Extend existing carport structure by 3m & convert to garage. Construct porch to over front door - This application affects the character and appearance of Angmering Conservation Area. This application affects the settings of a Listed Building

Grey Barn Rectory Lane Angmering

Thank you for your internet representation made on 3rd June 2019 which has been recorded as '**an objection**' with the comments as follows:

DRAWING TITLE
Proposed Porch –
Front Elevation of Existing House
Showing the Proposed Porch

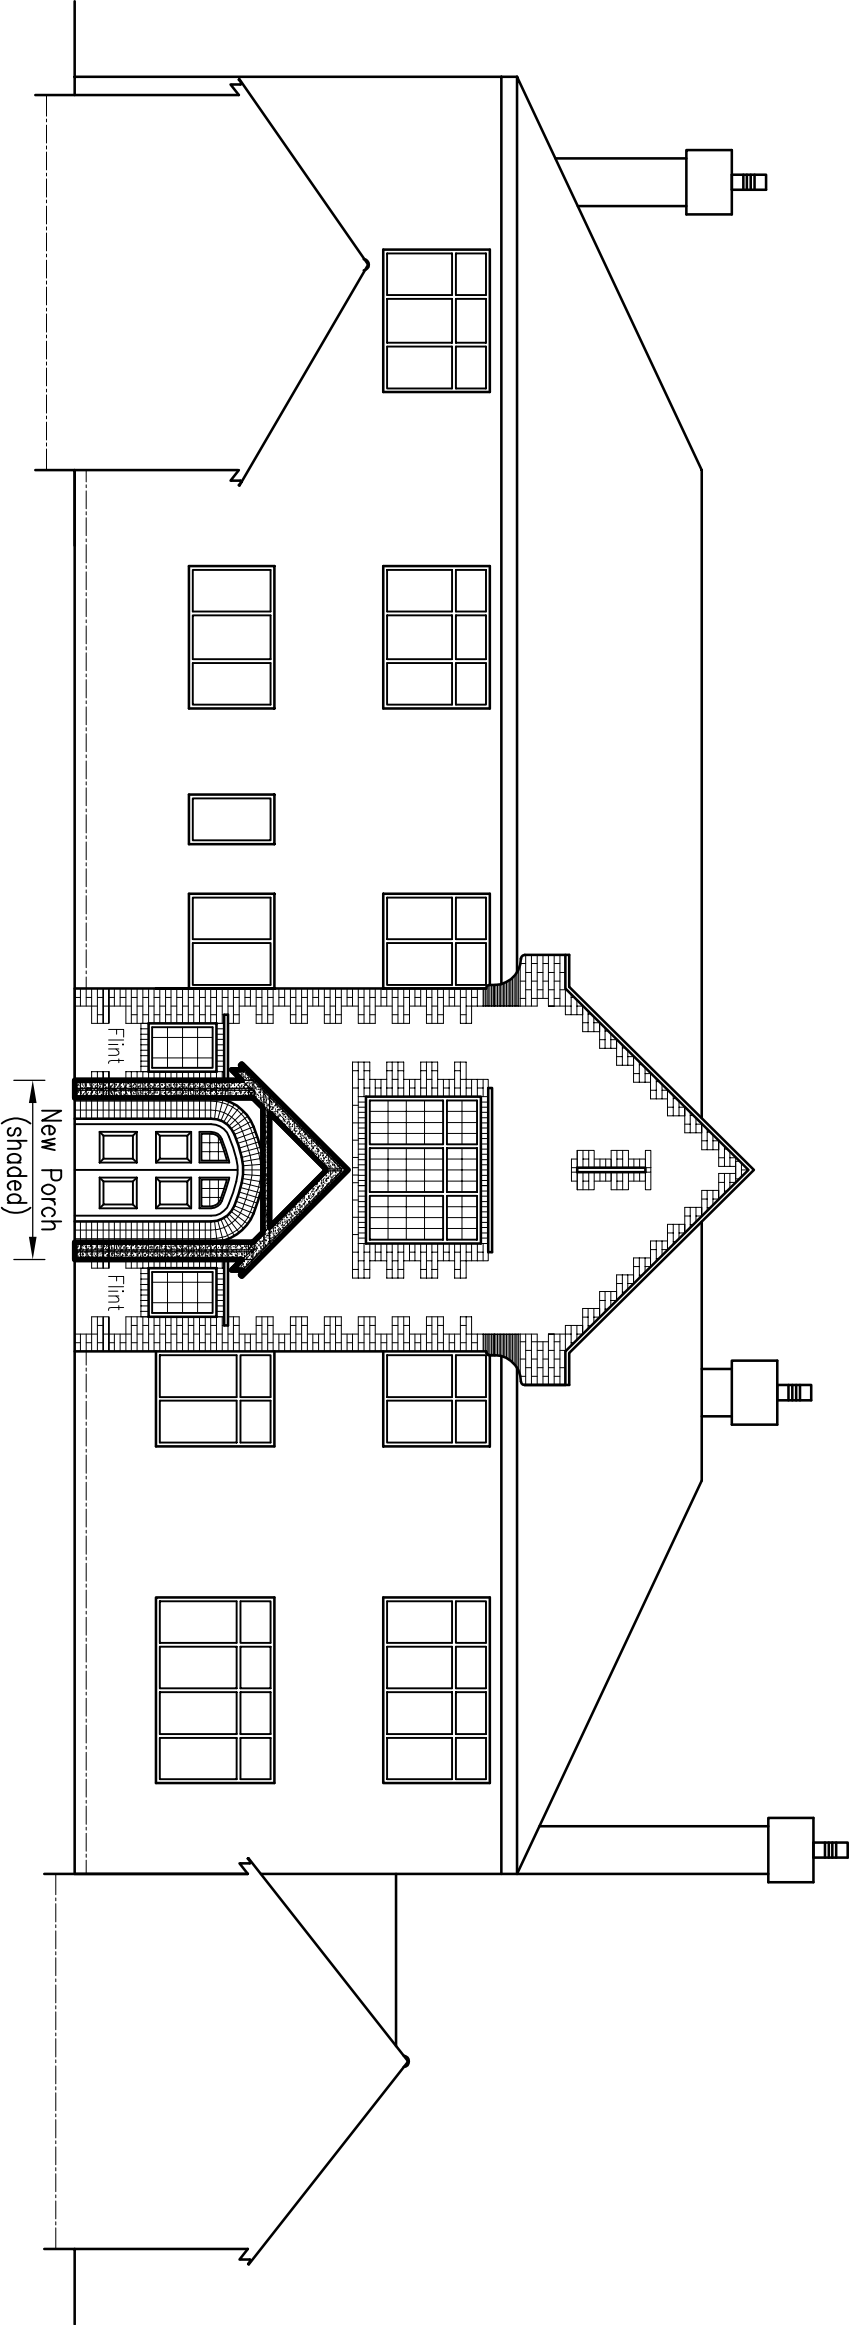
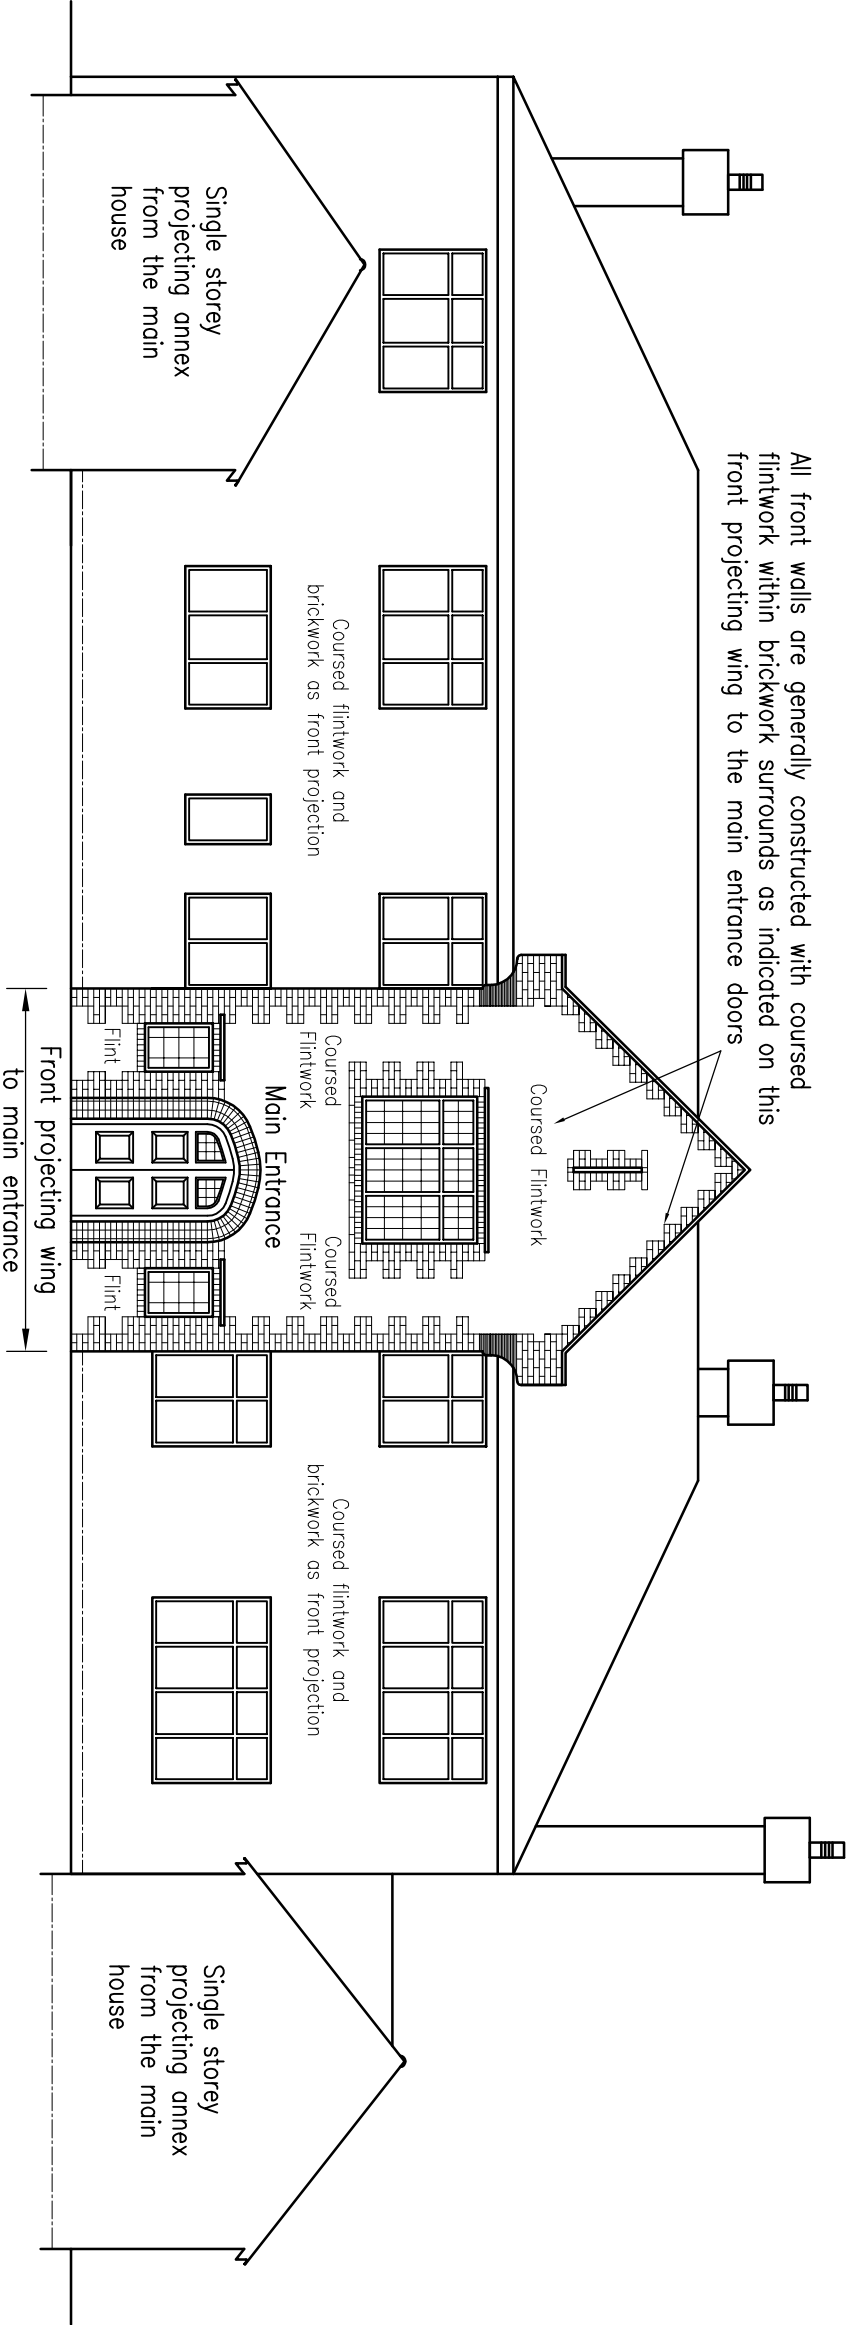
The existing doorway is an attractive feature of the building and the proposed porch will detract from that appearance. It is suggested that the garage doors should be of a simpler design reflecting the simplicity of appearance and form of the existing garage building. Although minor in extent these alterations will detract from the existing building and from its significance, and would also, therefore detract from the character and appearance of the Conservation Area. This design is in contradiction of NPPF 2018 Paragraph 192 (heritage assets - includes Conservation Areas) and Arun District Local Plan 2018 Policy HER DM3 (Conservation Areas) and HER SP1.
